DATE	January 4, 1980	JOB NO.	47-2-0003
ATTENTION	Mr. Subas Shaw, District Engineer		
RE:	Casita Vista Subdivision - Drainage		
RECEIVED			
JAN 6 1980

Re: Casita Vista Subdivision drainage plan

Reference: Casita Vista Development

CASITA VISTA

CITY OF ALBUQUERQUE
THIS MICROIMAGE IS THE BEST
POSSIBLE REPRODUCTION DUE
TO THE POOR QUALITY OF THE
ORIGINAL DOCUMENT

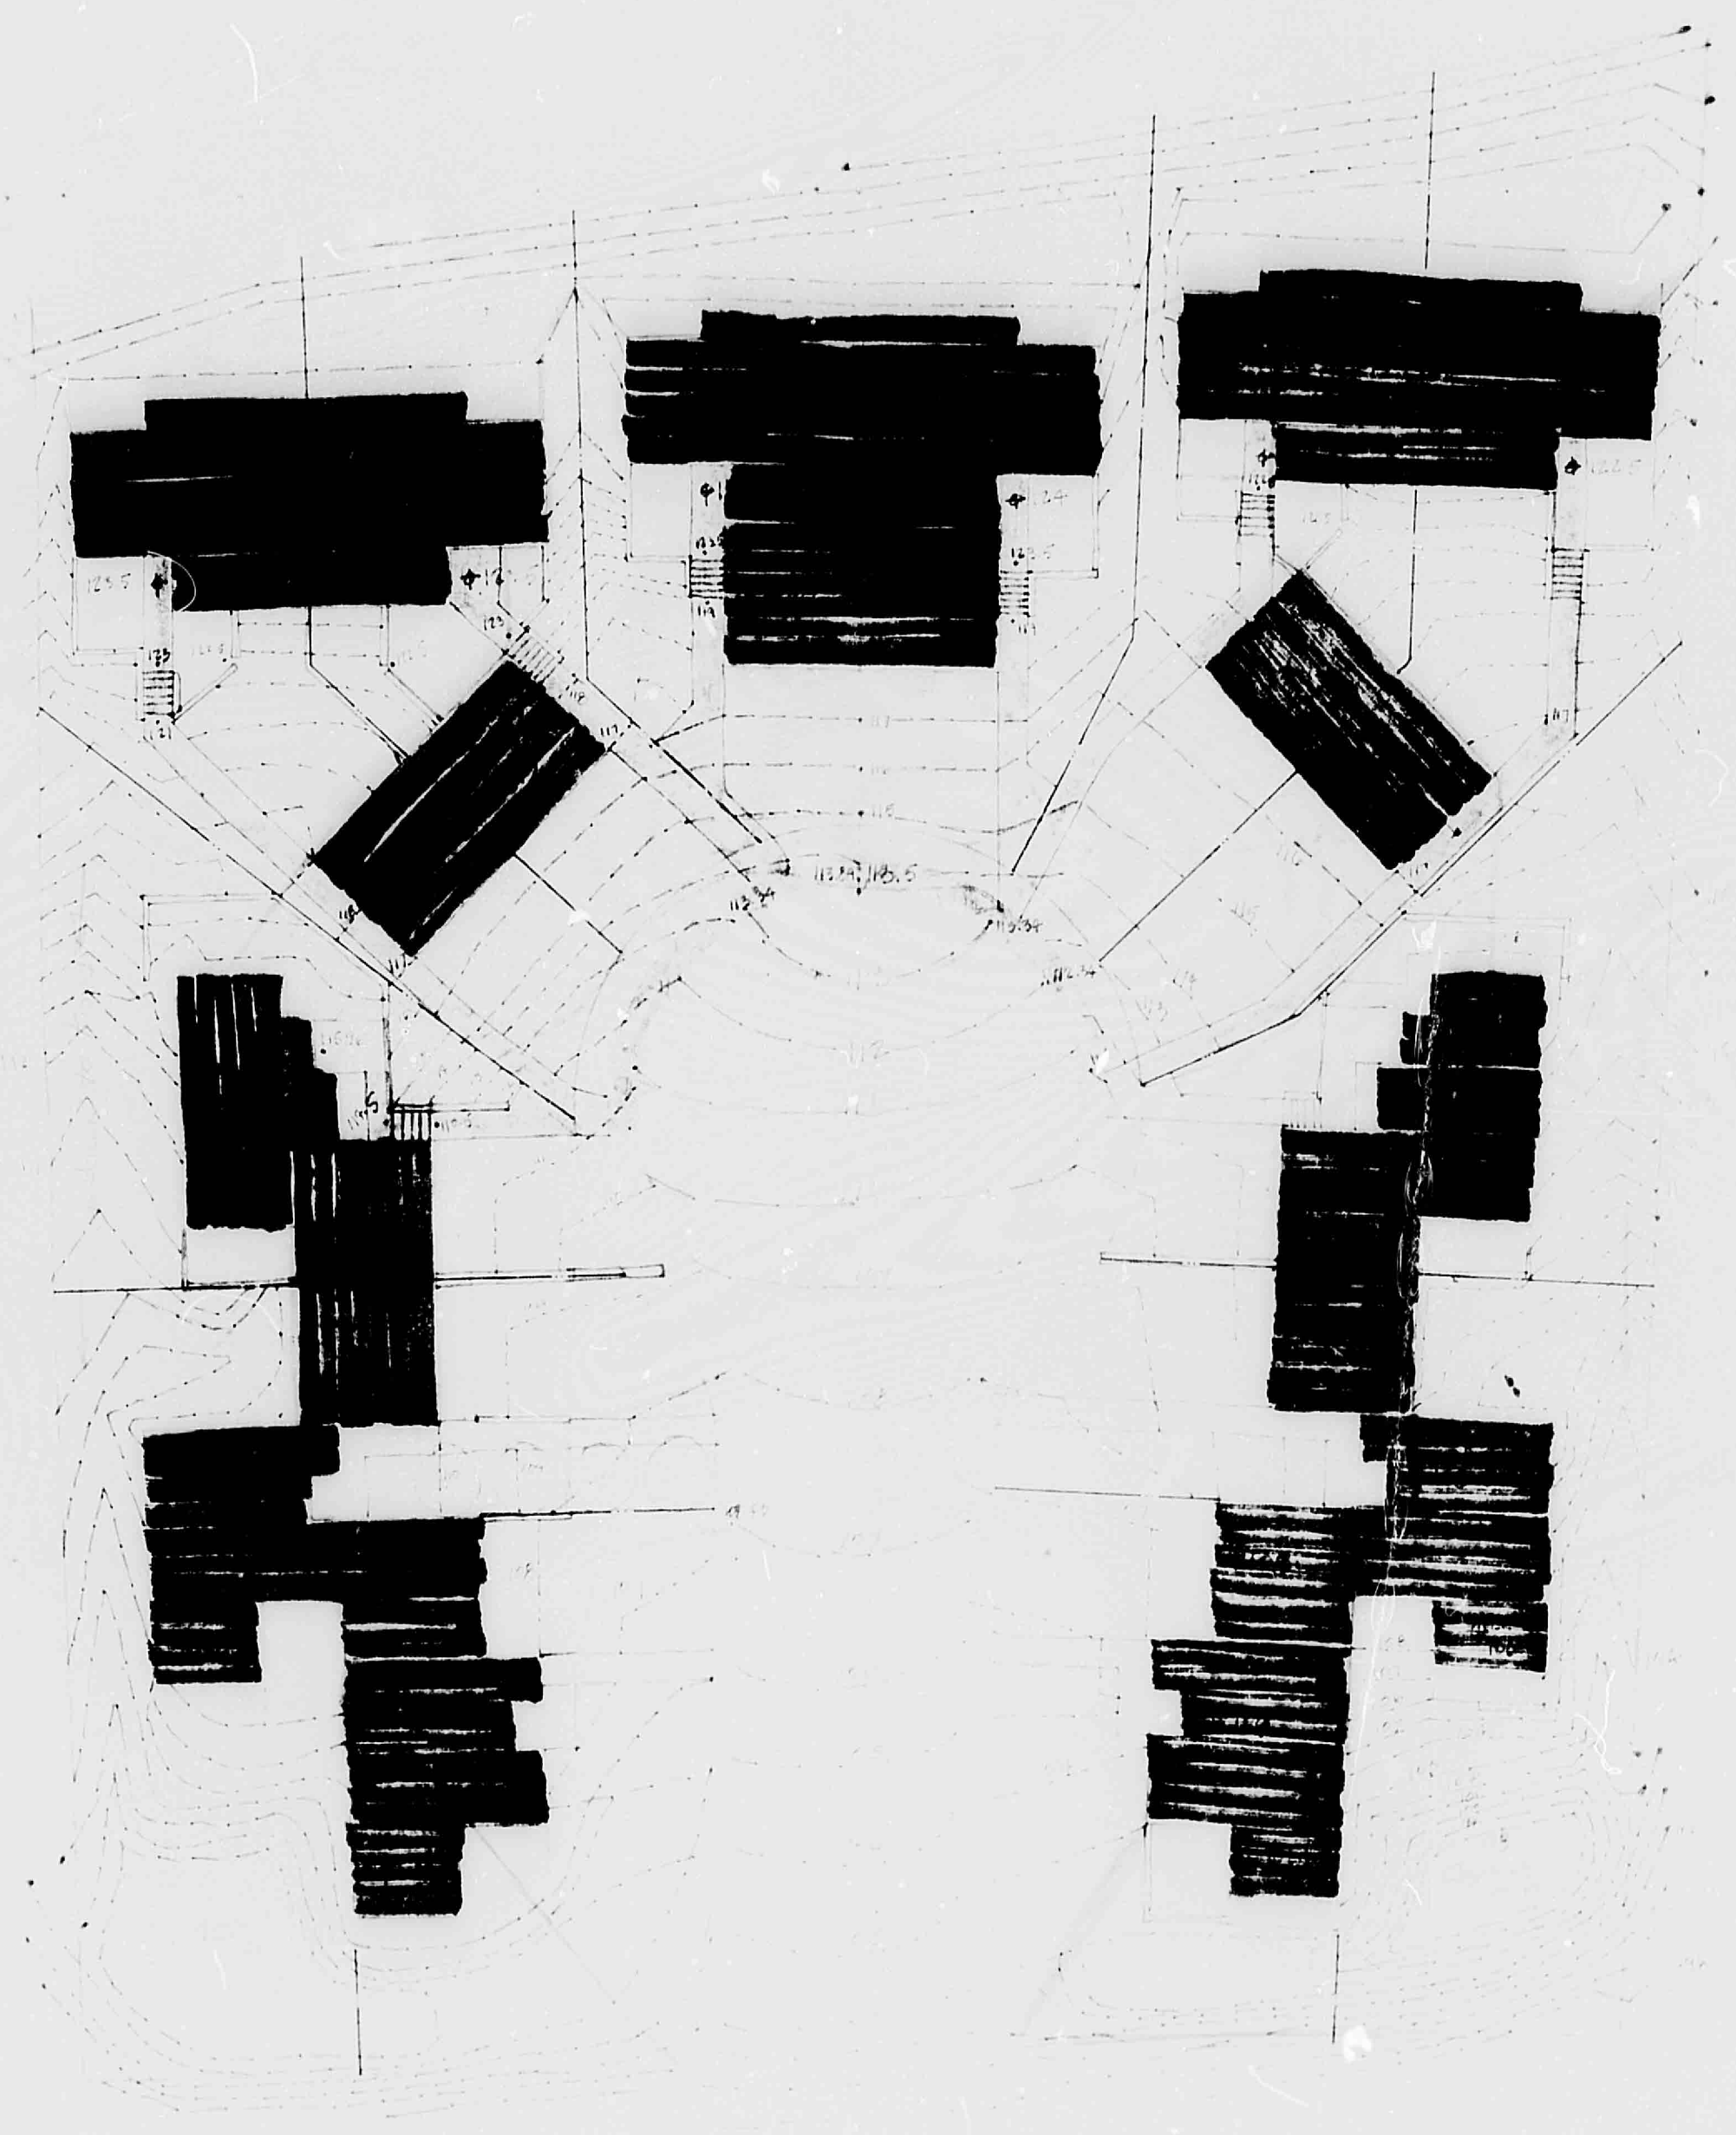
As we discussed, the District policy calls for no acceptance of any surface runoff into the District facilities, provided it threatens the damage to the District property and facilities. The Arenal Main Canal in the vicinity of your project is concrete lined and uncontrolled runoff would cause damage to the concrete lining.

- 1) The outlet drain pipes should be connected into one main drain pipe.
- 2) Only one drain inlet will be permitted from your property to drain into Arenal Main Canal.
- 3) The 4" drain pipe should drain directly into the canal. No sheet flow into District banks will be permitted.
- 4) Adequate cover should be provided over the drain pipe to avoid any damage due to District vehicles.
- 5) The developer or the City will be responsible for proper maintenance of the drainage system.
- 6) It is expected that the runoff received into the system will be free from contamination, grease, silt, etc.
- 7) A license is required from the District for a drain inlet. Please furnish final plans with these modifications.

To accomplish this objective we propose to furnish each pond with a small outlet drain which would empty the pond at a controlled rate. The discharge from these drains would be collected into two 4" diameter PVC pipes (one draining to the NE corner of the parcel and one to the SE corner). Flows would be released at the toe of the embankment onto a small rip rap pad and would sheet from the pad into the Arenal Drain. Peak discharge from the two pipes combined would be limited to 1 cfs for the "pond full" condition.

PLATE 3
 DRAINAGE MANAGEMENT PLAN
 CASITA VISTA
 UNIT 2

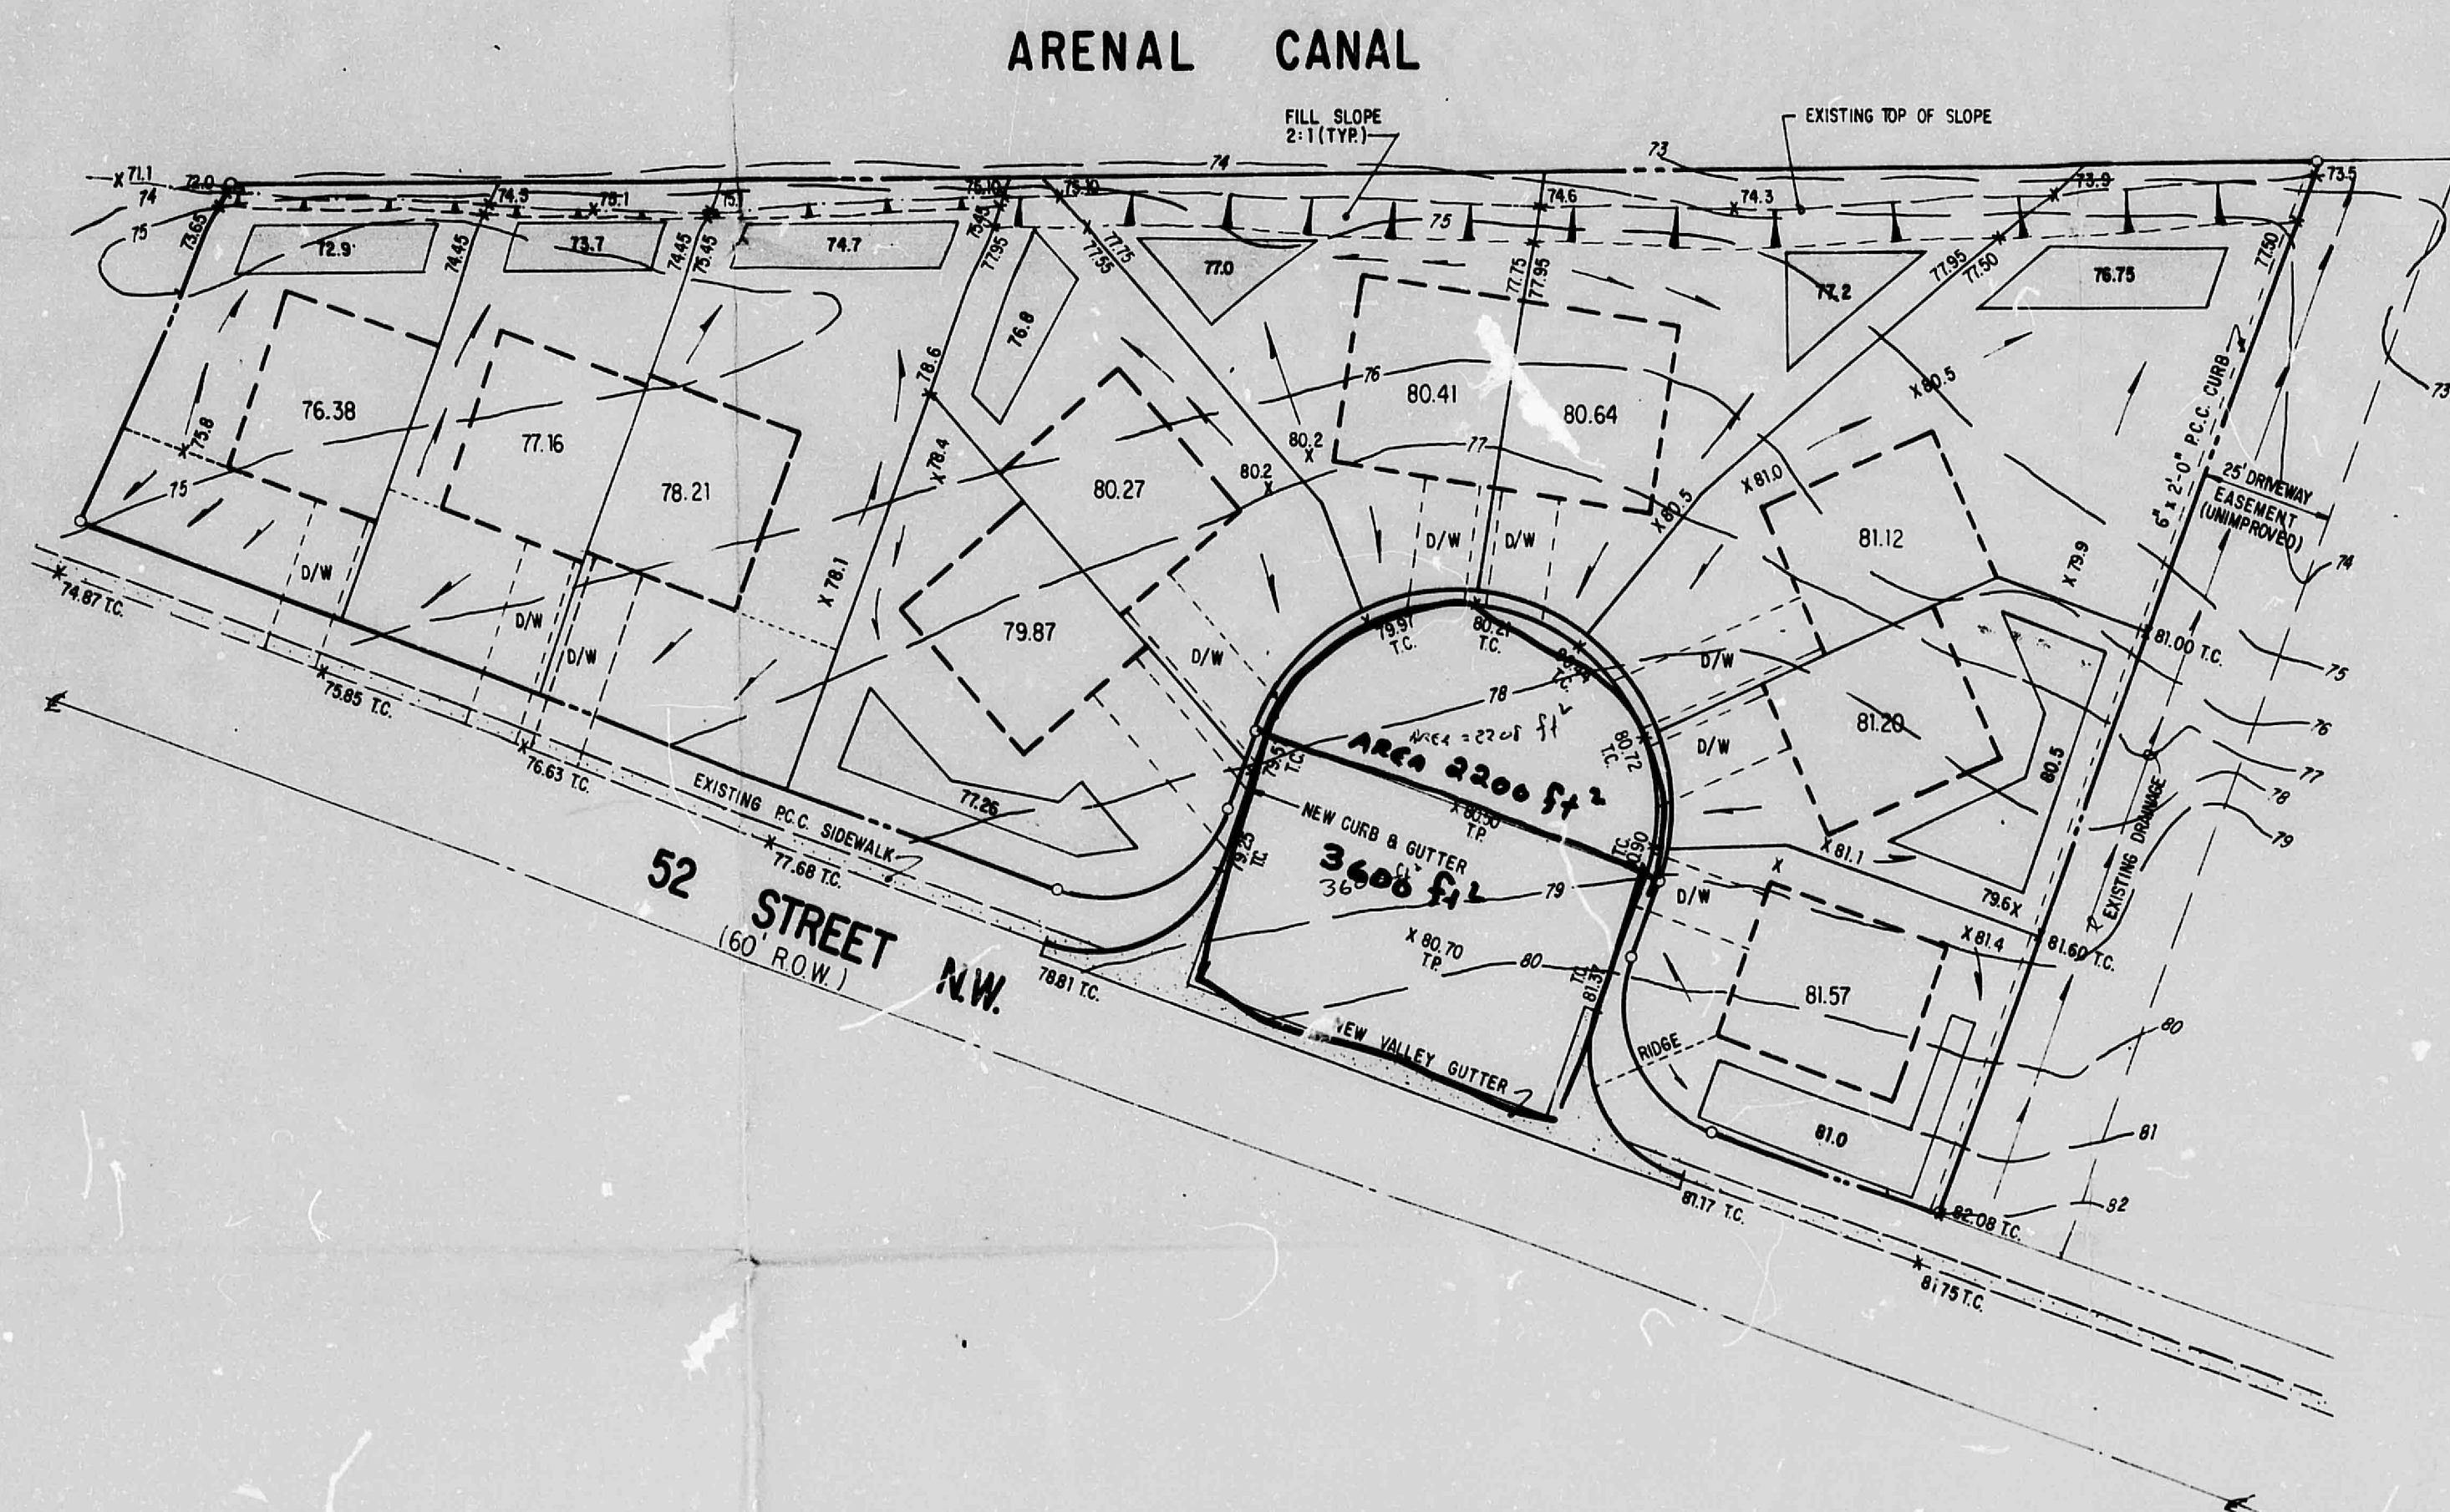
I have reviewed the drainage report for the referenced development, and I cannot concur with the proposal submitted.

A field investigation has revealed that the soil in place is mostly loose alluvial sand with much greater permeability than that exhibited by the soils of the east alluvial fans where a C value of 0.4 is usually adopted. I believe that the existing conditions do not warrant the use of a runoff coefficient C greater than 0.15-0.2.

I also object to the proposal of raising the land by importing fill material and conveying the developed runoff to 52nd Street. The minimal nature of the storm drainage facilities in the valley makes it imperative that no additional discharge be conveyed to already overload facilities, or preempt some of their capacity. My Assistant, Fred Aguirre, has reviewed the computation submitted and found them inadequate (see attachment). I concur with his disagreement, particularly with the use of a runoff coefficient of 0.65 for southwestern landscaping which is normally underlaid by polyethylene film; a value of 0.9 should instead be used.

I further find the drainage report inadequate in terms of the attention paid to the vertical bank, 10 to 15 ft. high, adjacent to the Arenal Canal: Will the ponding areas on top of the slope cause bank failures? A soil engineer report will be required to verify the stability of the slope with the design proposal submitted. Given the circumstances of the site, 100% retention is required. As you may be aware, the development plan shown on the drainage report is at variance with the plan submitted to the Planning Department, and a new action by the E.P.C., will be required. I am forwarding a copy of the plan to Mr. Don Peterson, for his review and follow up.

① I CAN NOT AGREE WITH SOME OF THE AREAS DESIGNATED FOR THE DIFFERENT ITEMS ON PAGE FIVE OF THE REPORT. SEE MY CALCULATED AREAS ON PAGE FIVE.

② I DON'T AGREE WITH THE "C" FACTOR DESIGNATED FOR SOUTHWEST LANDSCAPING.

③ THE ITEM DESIGNATED AS PAVING (STREET) DOES NOT AGREE WITH THE AREA I CALCULATED FOR THE CUL-DE-SAC.
(IN REPORT) $370 \text{ sf.} \times 10 \text{ LOTS} = 3700 \text{ sf. TOTAL}$
(MY CALCULATIONS) 5800 sf. TOTAL . SEE GRADING PLAN

* ④ SINCE AN AVERAGE POND REQUIREMENT IS DESIGNATED FOR EACH LOT, I WOULD LIKE TO SEE A BALANCE FOR EACH LOT BETWEEN THE DRAINAGE AREA AND POND. THESE AREAS SHOULD BE OUTLINED AND THE POND VOLUMES CALCULATED (AND SHOWN)

⑤ SINCE U.B.C (UNIFORM BLDG. CODE) IS CONCERNED WITH THE CLOSE PROXIMITY OF THE POND TO THE STRUCTURE, WE SHOULD GET THEIR APPROVAL.

How about positive drainage?

Ponds adjacent to the canal should be designed against any failures.

Recommend an erosion sedimentation protection plan for this particular development. Our waterways should be protected from any increase in suspended solids and sediment depositing in the canal.
